SECTION 4.55(1A) MODIFICATION APPLICATION – SSD 6966 BUILDING R5, ONE SYDNEY HARBOUR, BARANGAROO SOUTH

This modification application has been prepared by Ethos Urban on behalf of Lendlease (Millers Point) Pty Ltd (Lendlease), pursuant to section 4.55(1A) of the *Environmental Planning and Assessment Act 1979* (EP&A Act) to modify Development Consent SSD 6966 relating to Residential Building R5 at Barangaroo South (the site).

## R5 ELEVATION SOUTH -WEST (WATERMANS QUAY)

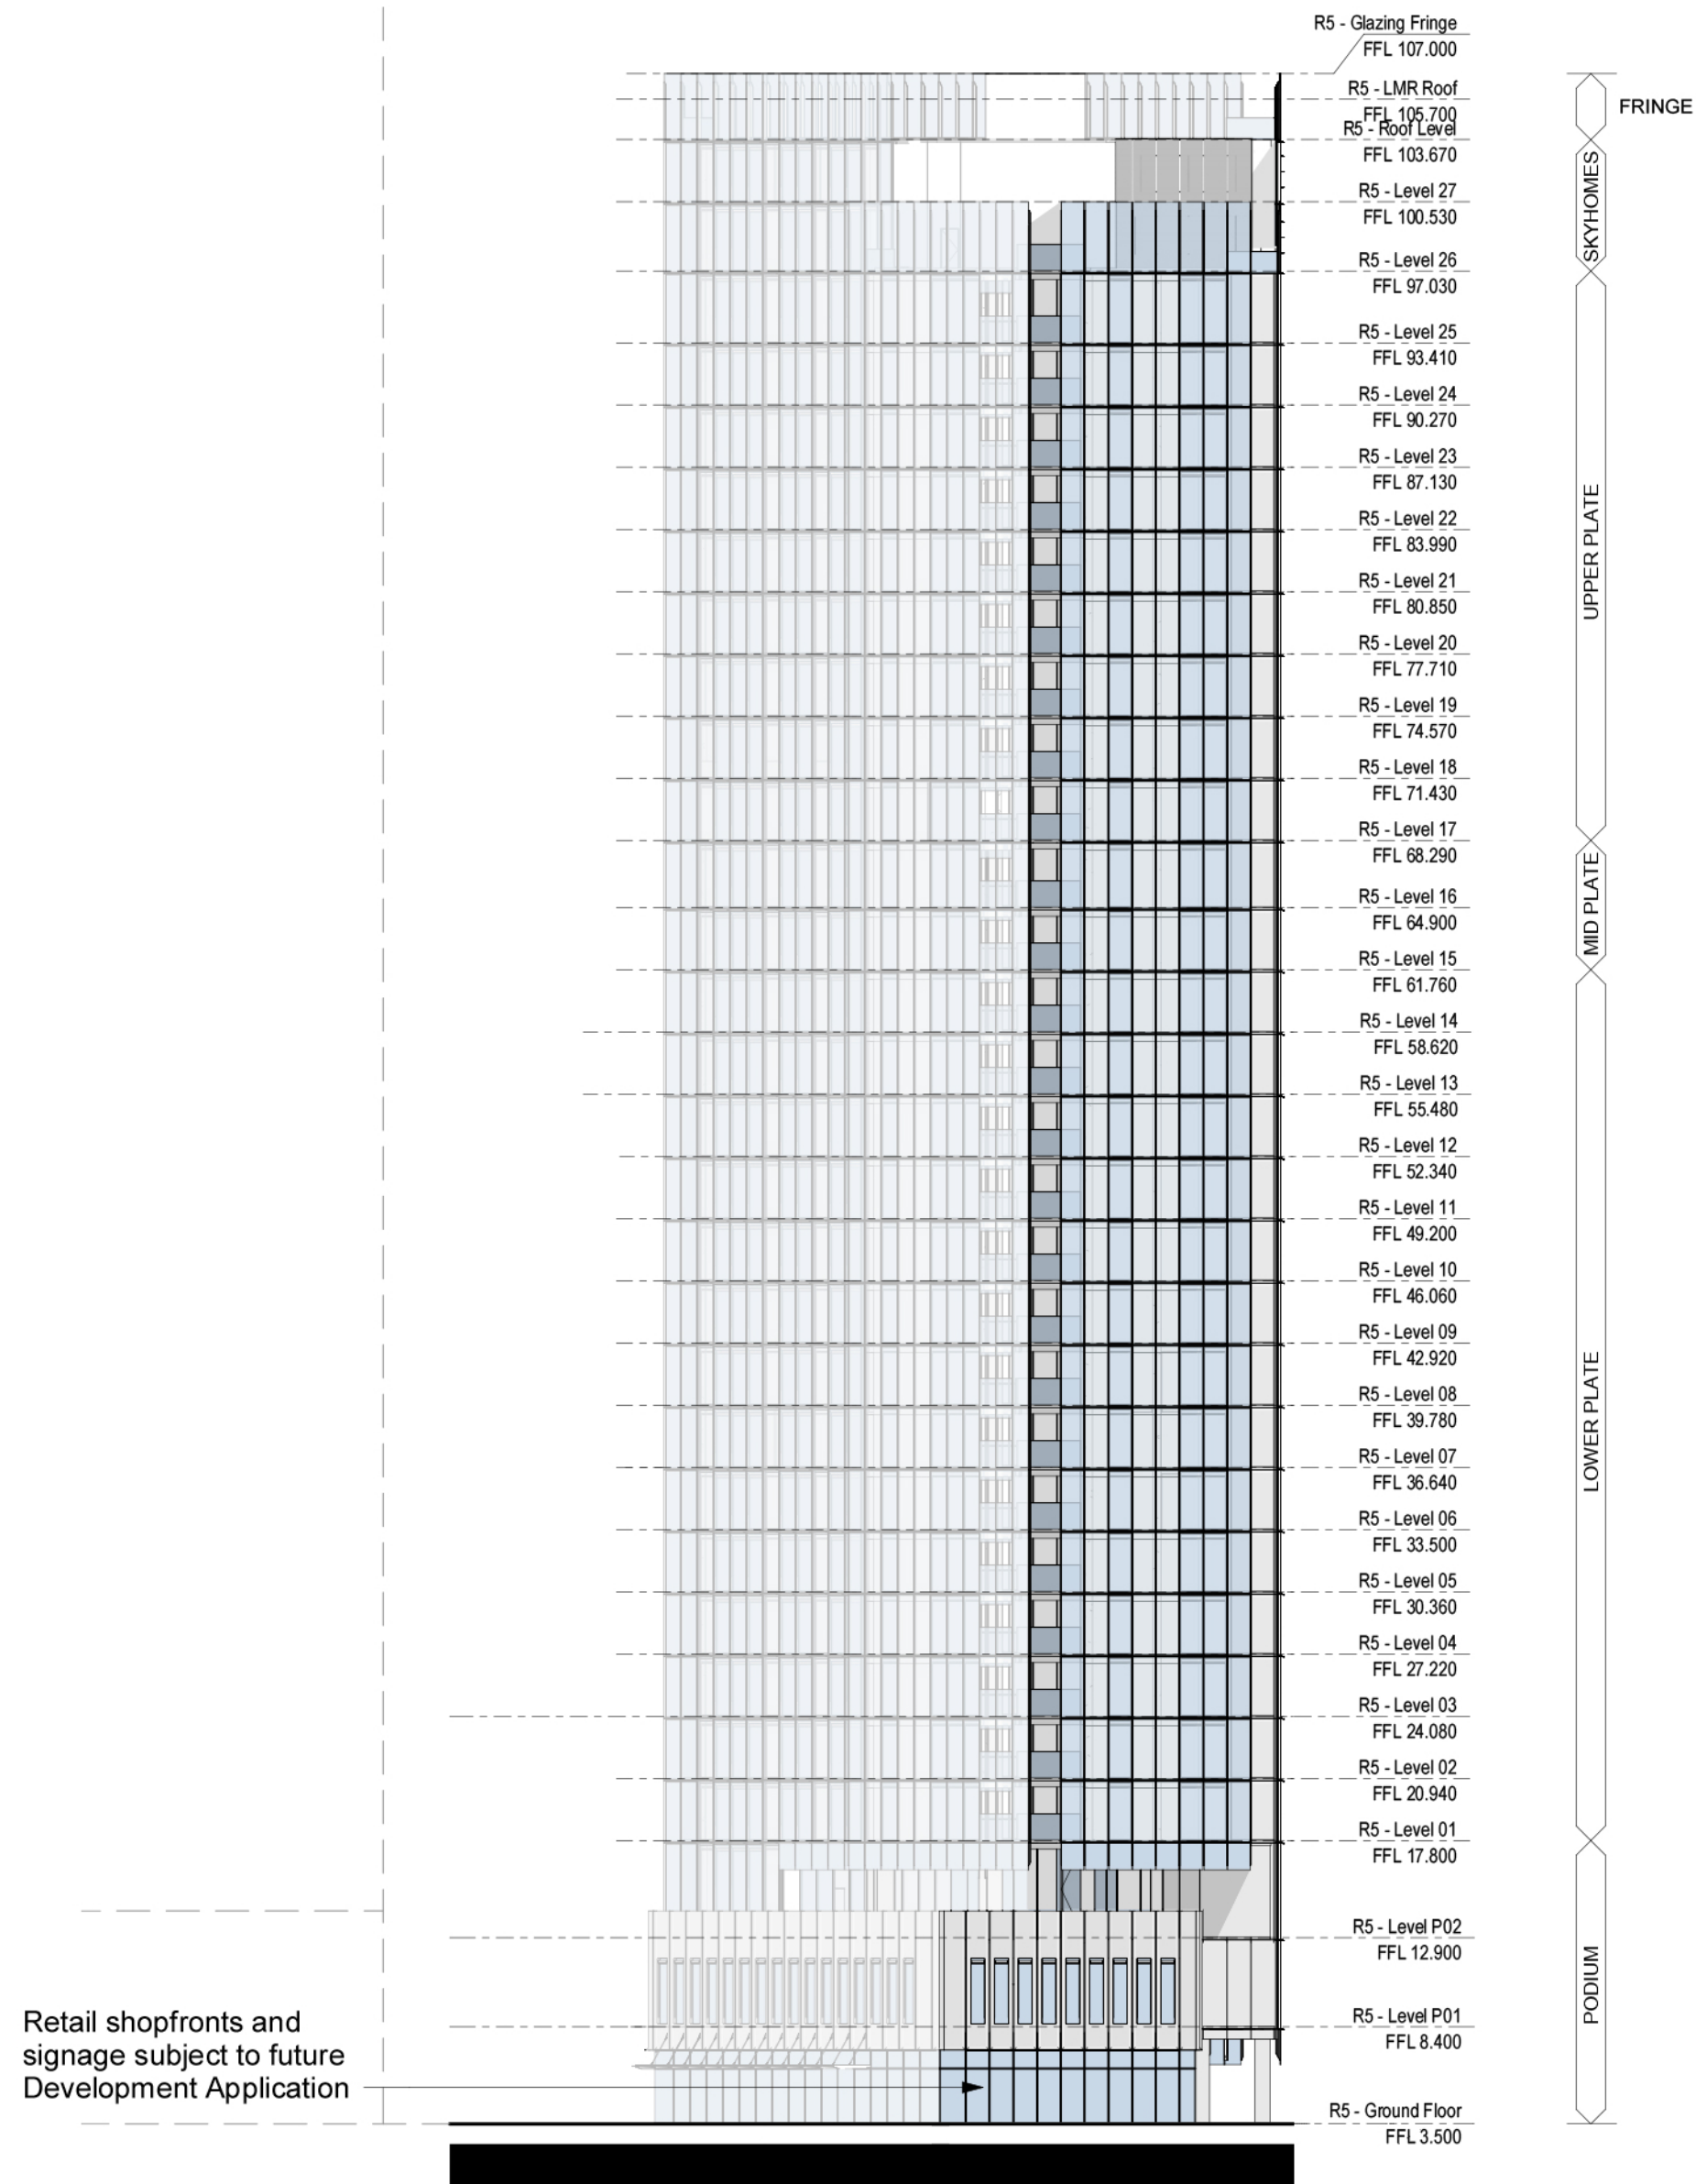
The proposed modifications include the installation of retail shopfronts. Under the current consent and within the existing stamped plans, the approval of these shopfronts is subject to a future, separate individual design process and their own Development Application (DA). On a further design review, it is considered that providing for the shopfronts as part of an integrated approach will provide a better response to the broader architecture of the building and will result in a more cohesive design outcome together with the other shopfronts approved under Building R4A (SSD 6964) and SSD 6965 (as amended by SSD8892218).

It is proposed to reconfigure the façade at the ground level elevation to facilitate the following:

- Additional retail shopfronts/entrances around the ground floor of the building.
- Additional door for fire booster cabinet fronting Hickson Road.

Southwest Elevation

Approved

Proposed

Figure 3 Façade changes on the southwestern elevation
